EPC STORMWATER REVIEW COMMENTS  
IN ORANGE BOXES WITH BLACK TEXT

PCD PROJECT NO: PPR2232 & MS232

PROJECT  
FALCON STORAGE PARCEL  
PART W 1/2 SEC. 1, T.13S., R.65W., 6TH P.M.  
EL PASO COUNTY

SHT. NAME  
GRADING AND EROSION CONTROL PLAN

TEMPORARY SEDIMENTATION BASIN (TSB)

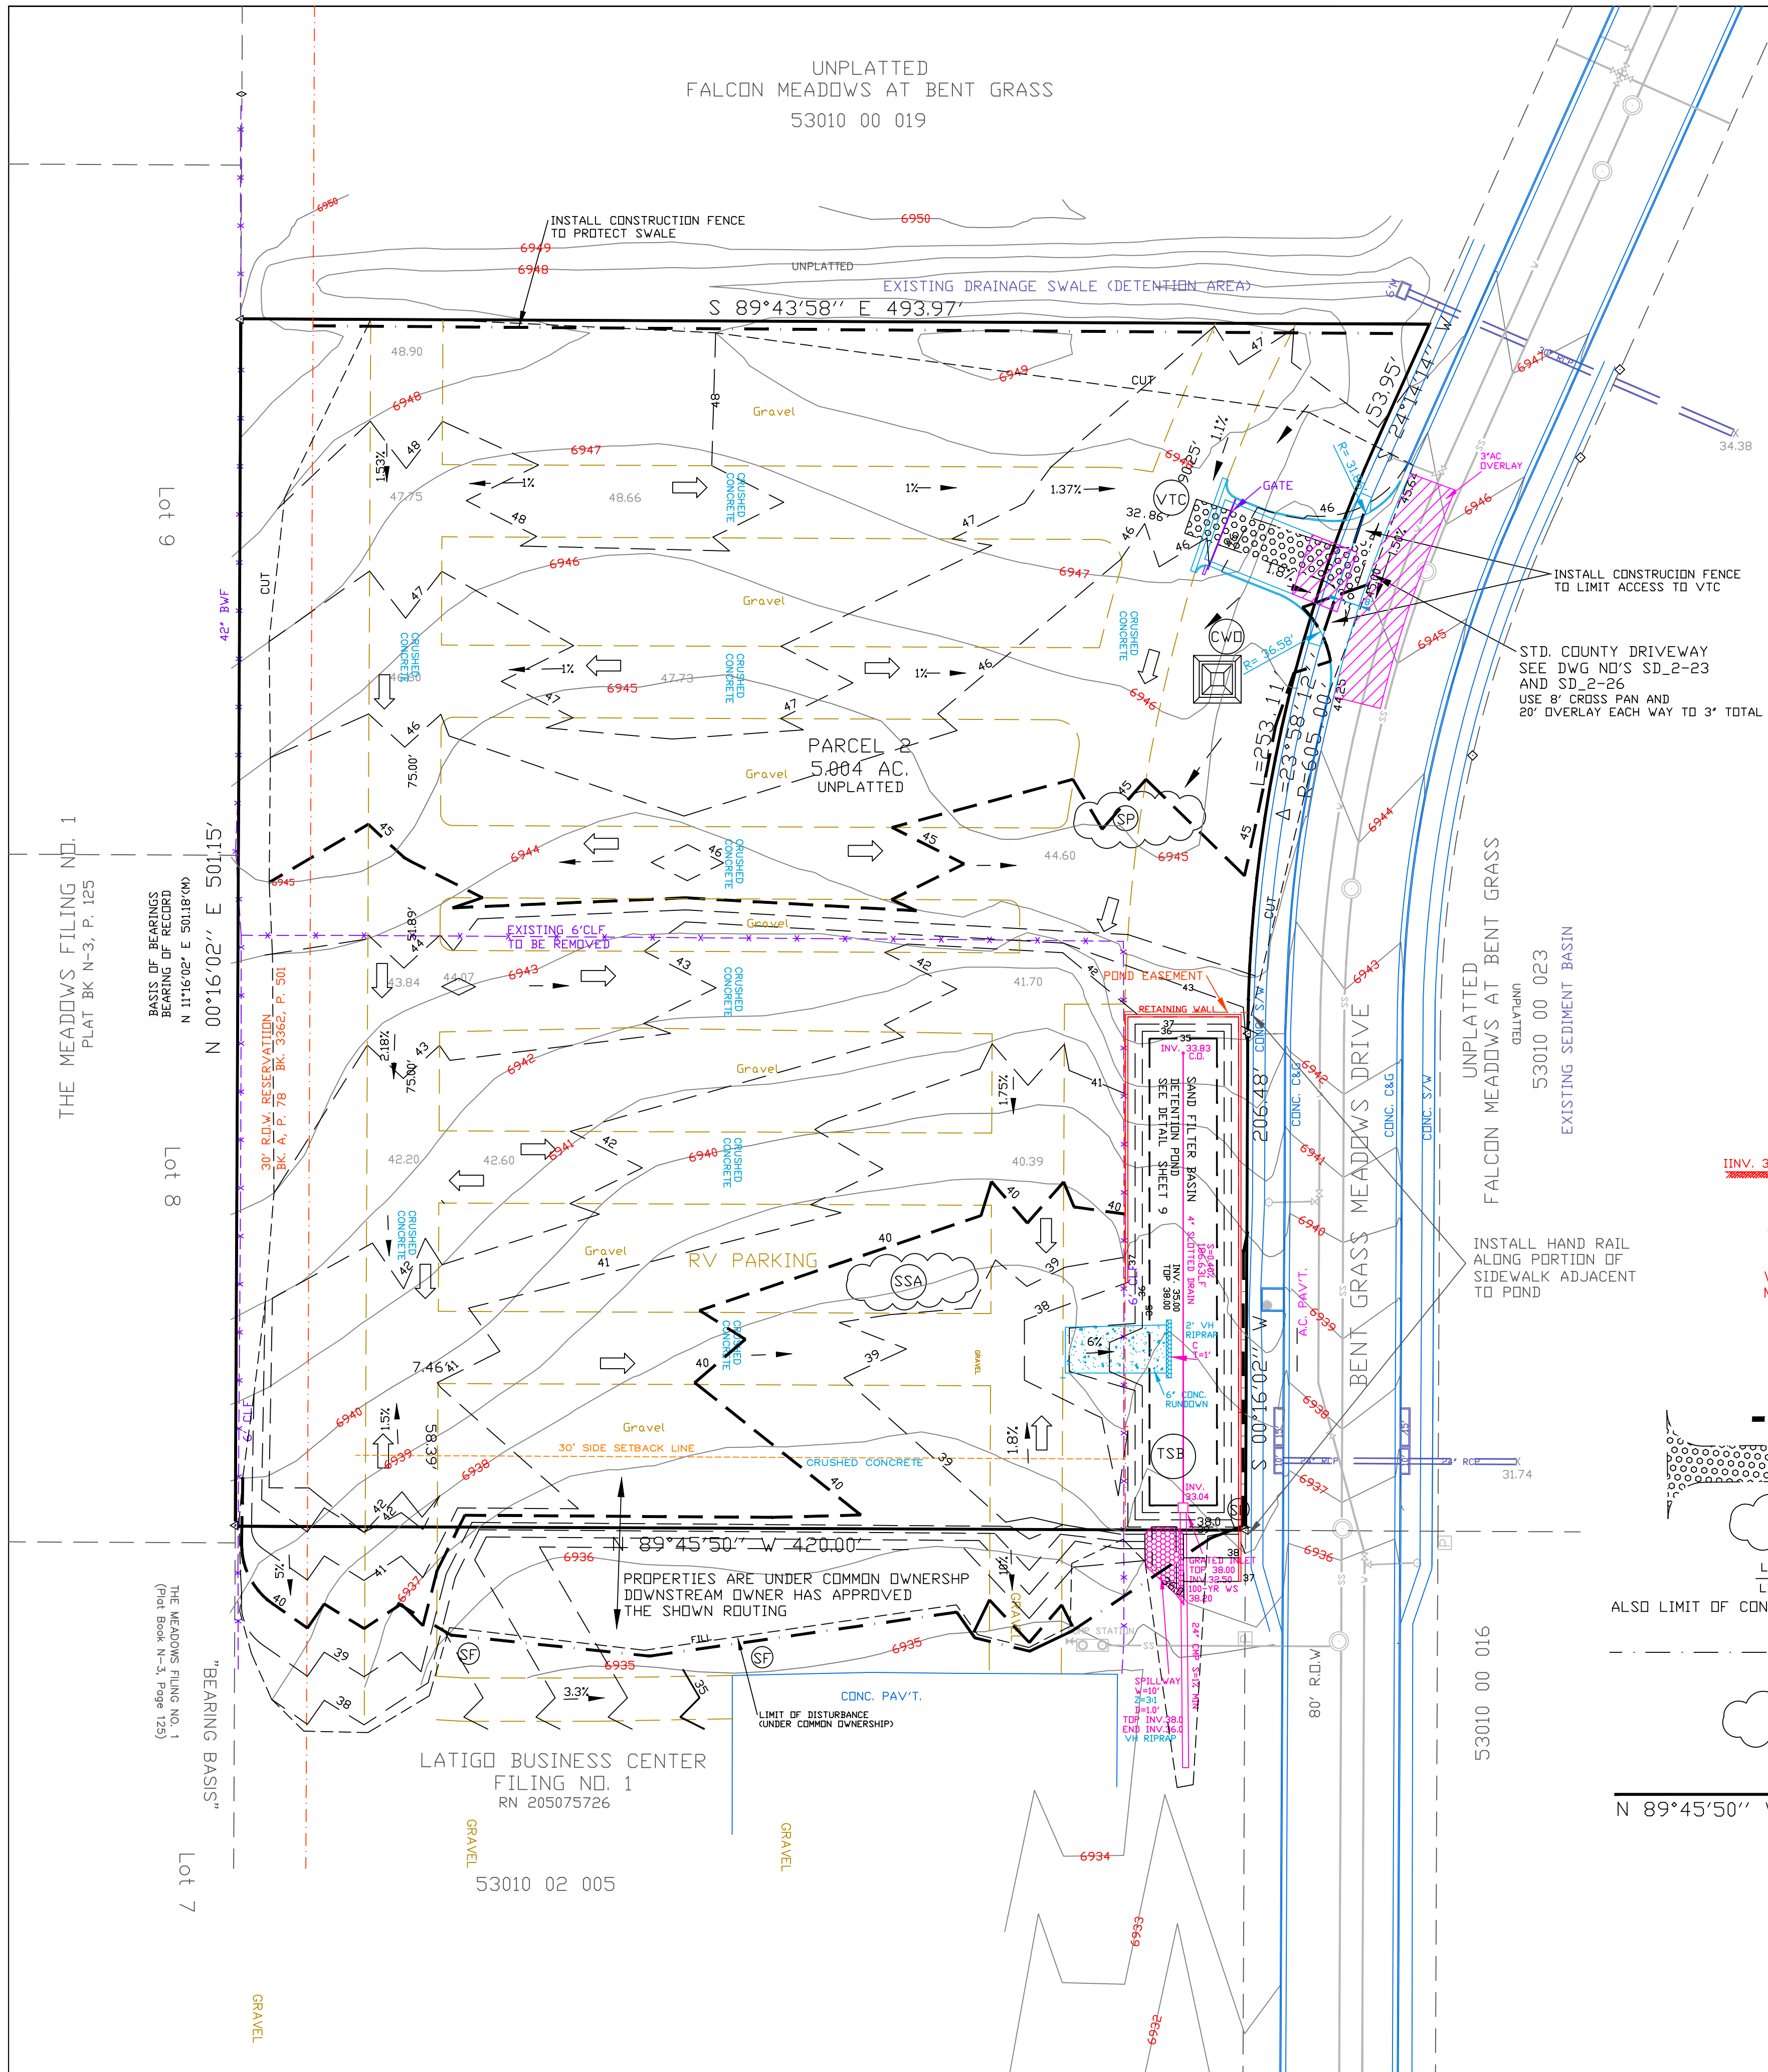
change to "Water Quality" this is not a detention pond. unresolved.

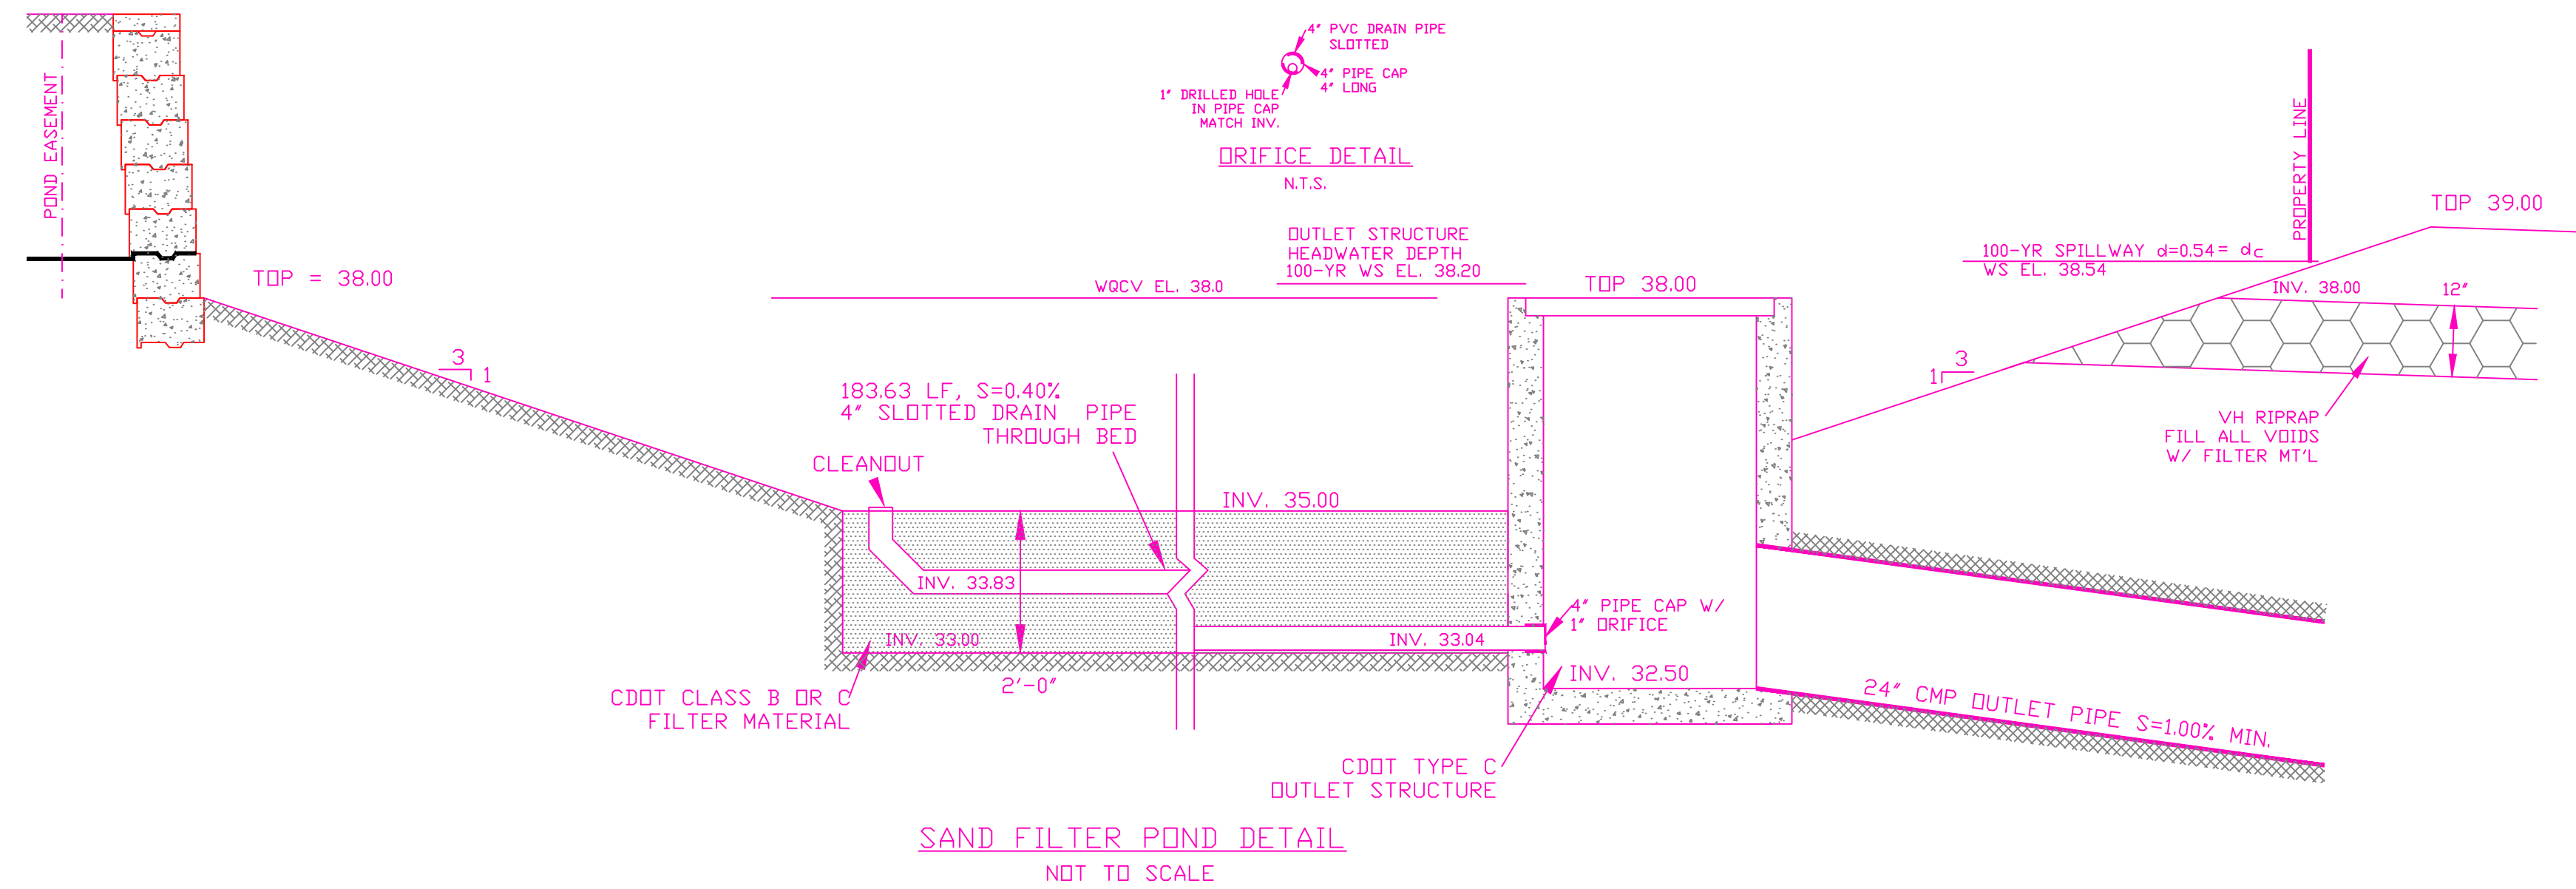
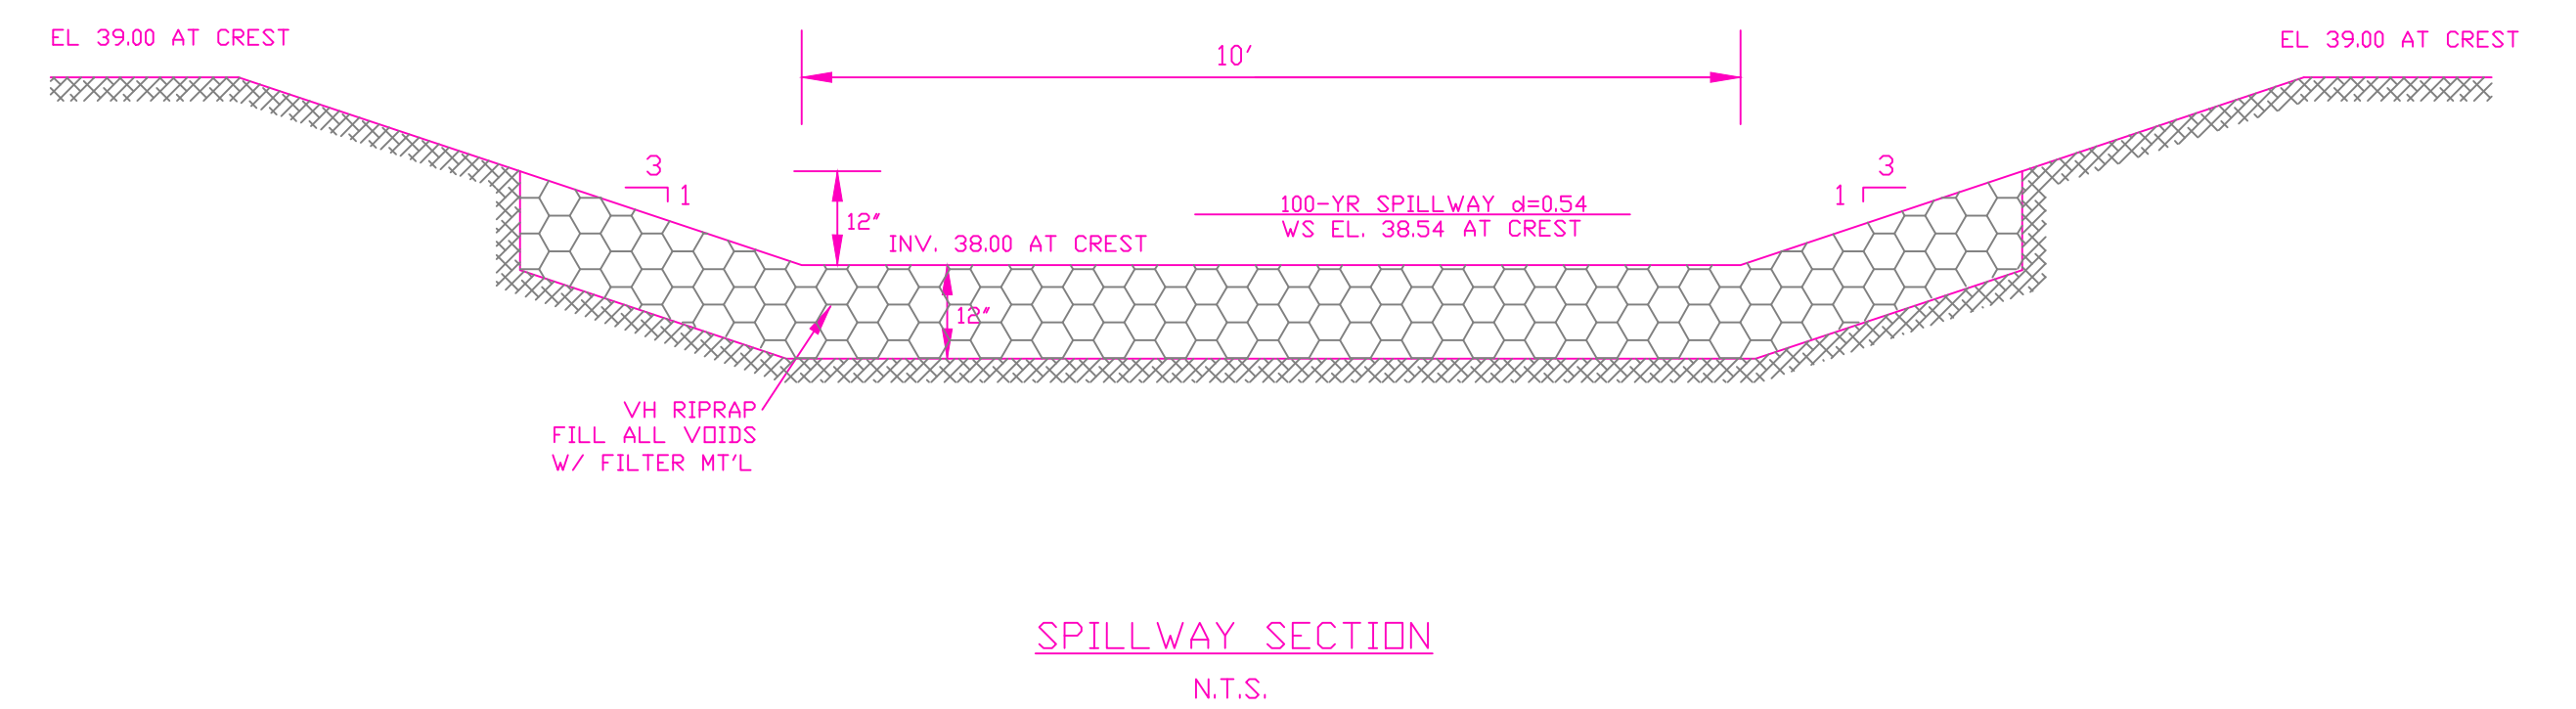
orifice size doesnt match. Change 1" to 2" to match design calcs
